To : Tajinder Rehal
From : Nicola Slade – Contaminated Land Officer
cc :
Date : 13 December 2021 **File Ref:** 03/00126/CLHIST Depot, Old Malden Lane
Re : **21/01894/FLH Villa Ray 1 The Powdermills, Old Malden Lane, Worcester Park, KT4 7PZ**

Single Storey Rear & Side Extension

**GROUND FLOOR PLAN
AS PROPOSED**

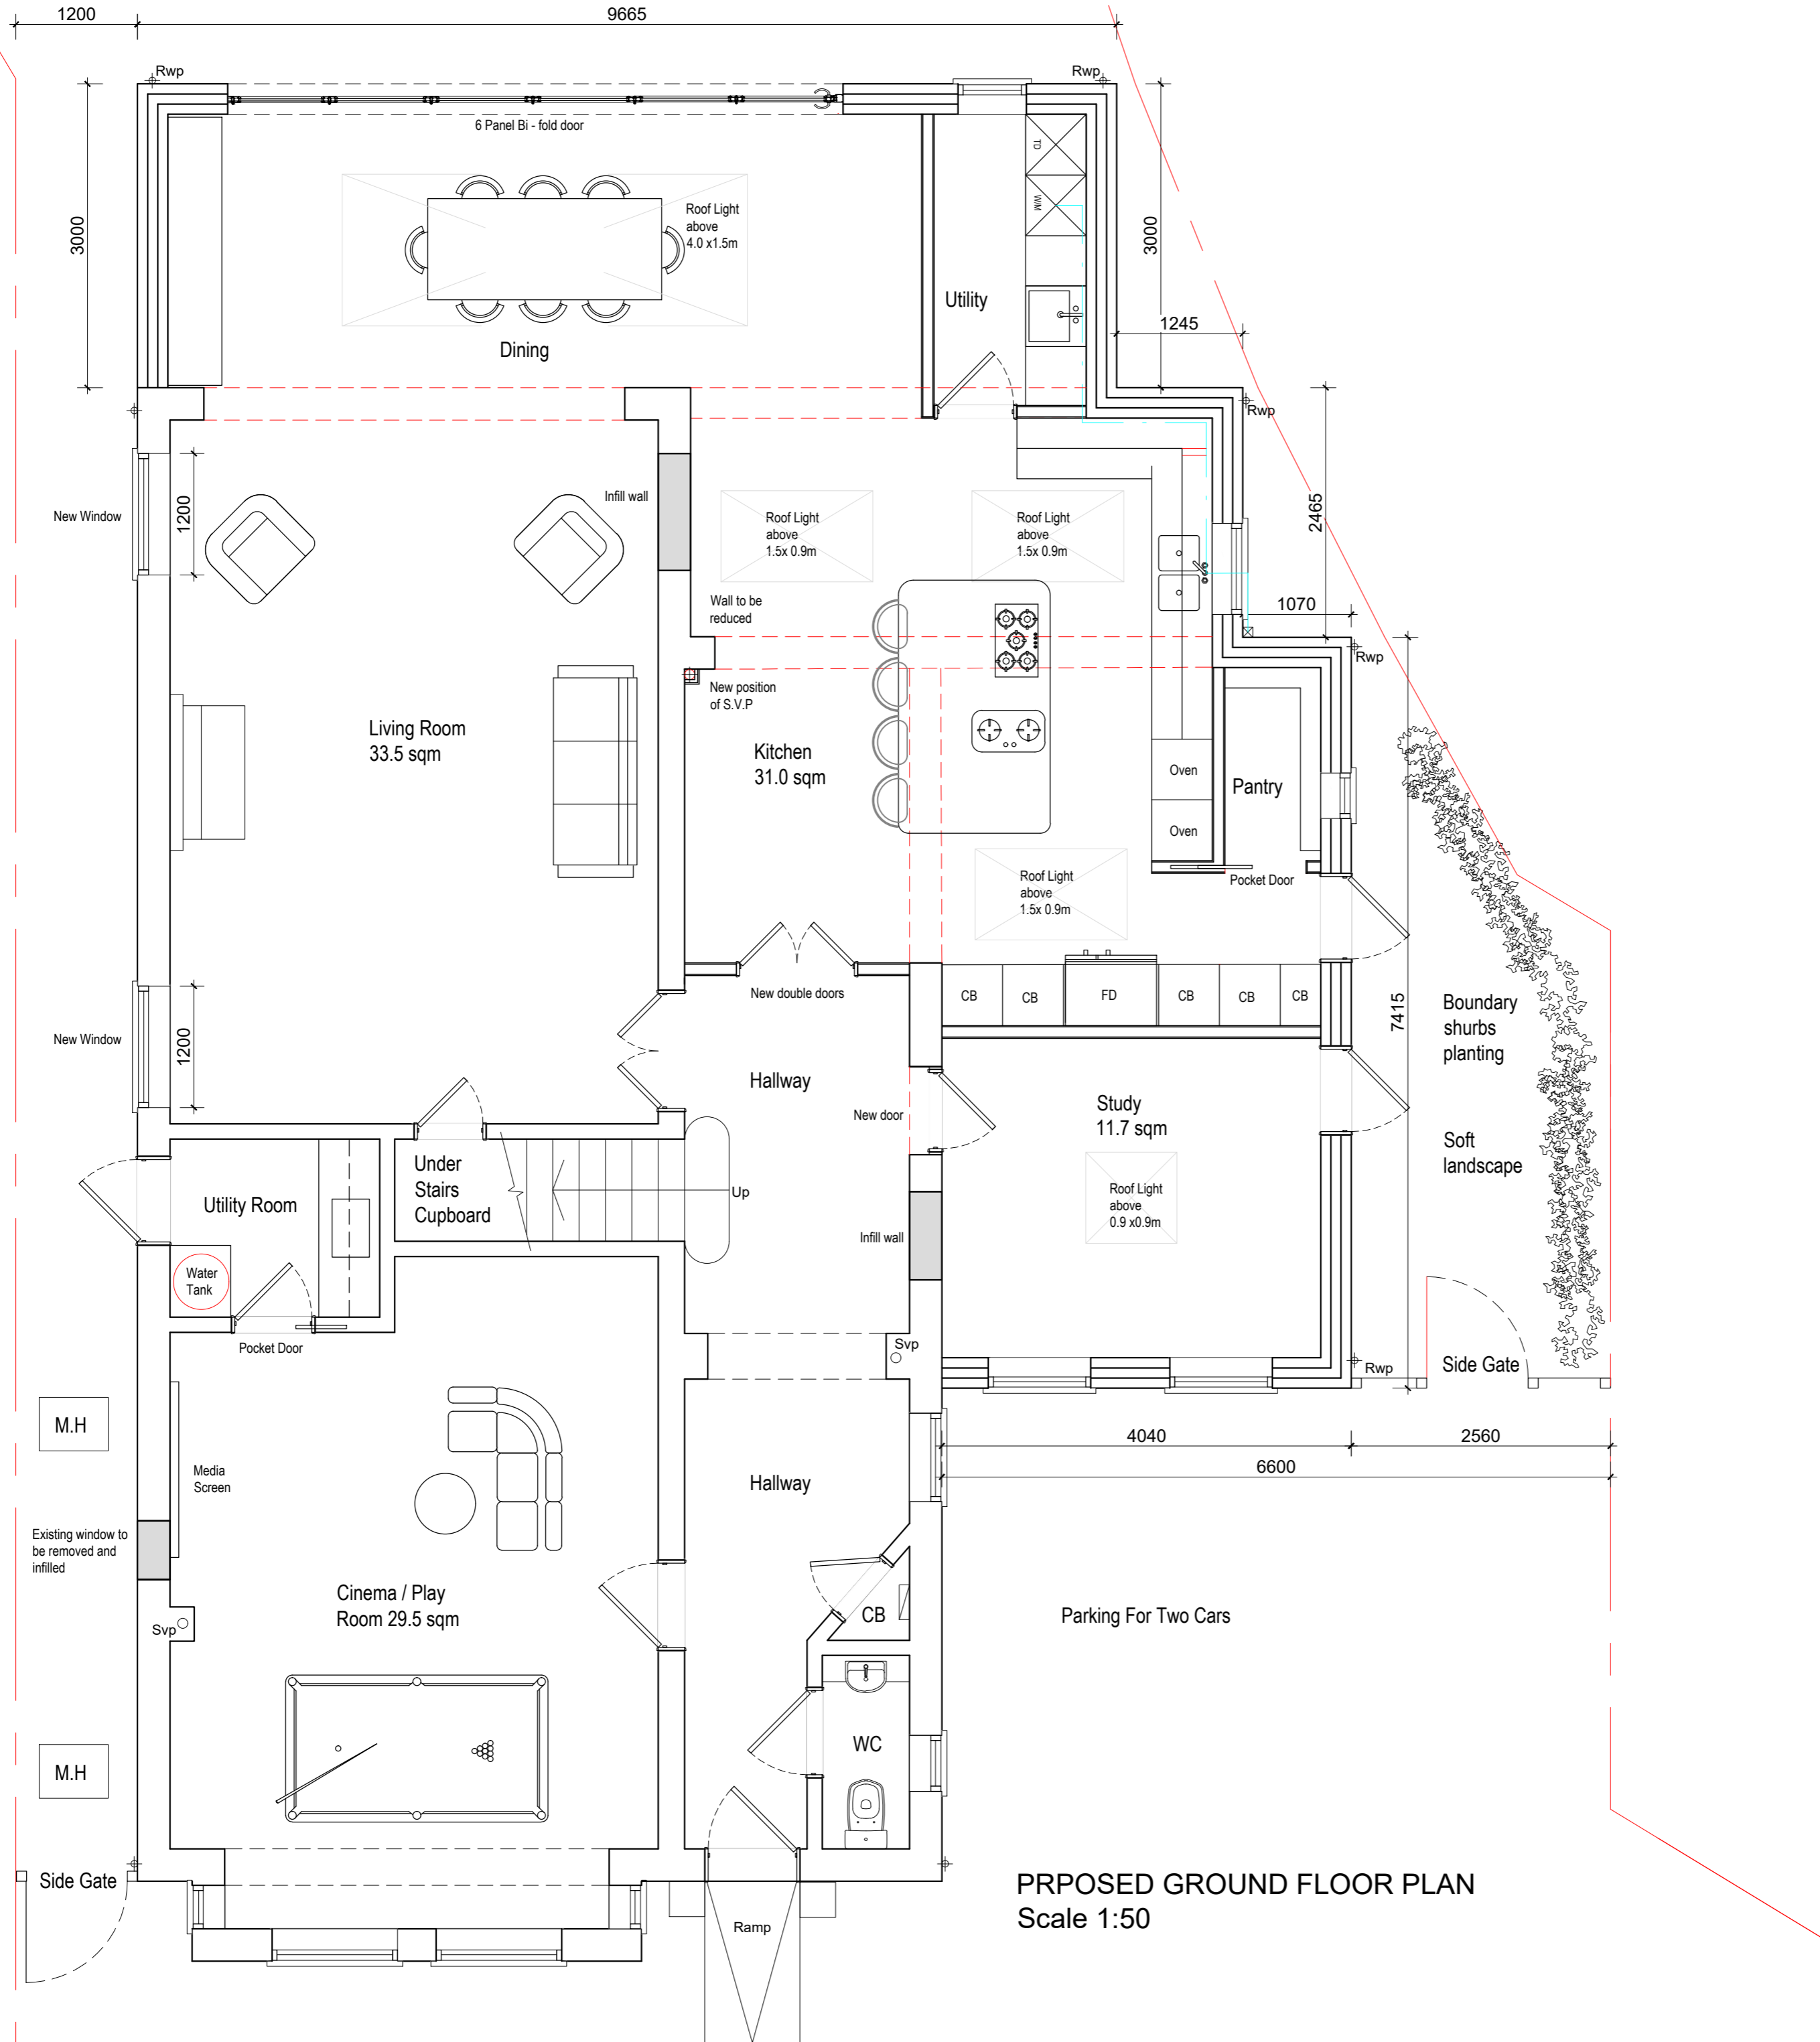
Before the property was developed in 2014, a ground investigation was carried out due to the site's proximity to a known contaminated site to the south west. Elevated levels of lead were found, believed to be from burning activities on the site. This area was remediated by excavating the contaminated soil, but EEBC records are unclear about the depth of the excavation. I would therefore recommend that the following informative be attached to any consent granted, requiring remedial action to be taken should contaminated materials be encountered during development, notably the excavation of foundations.

A previous site investigation carried out when Nos 1 and 2 Old Malden Lane were built found elevated levels of lead. The site was remediated by excavating the contaminated soil, but EEBC records are unclear about the depth of the excavation. It is therefore recommended that appropriate ground contamination health and safety precautions are taken during any excavation works. In the event that contamination is found at any time when carrying out the approved development, works should be suspended and it must be reported in writing immediately to the Local Planning Authority. An investigation and risk assessment must be undertaken and remediation carried out as is necessary, subject to the approval in writing of the Local Planning Authority. All waste soils must be appropriately categorised and disposed. See EEBC Planning Advice note on the assessment and remediation of contaminated land. Further advice may be sought from the Contaminated Land Officer.
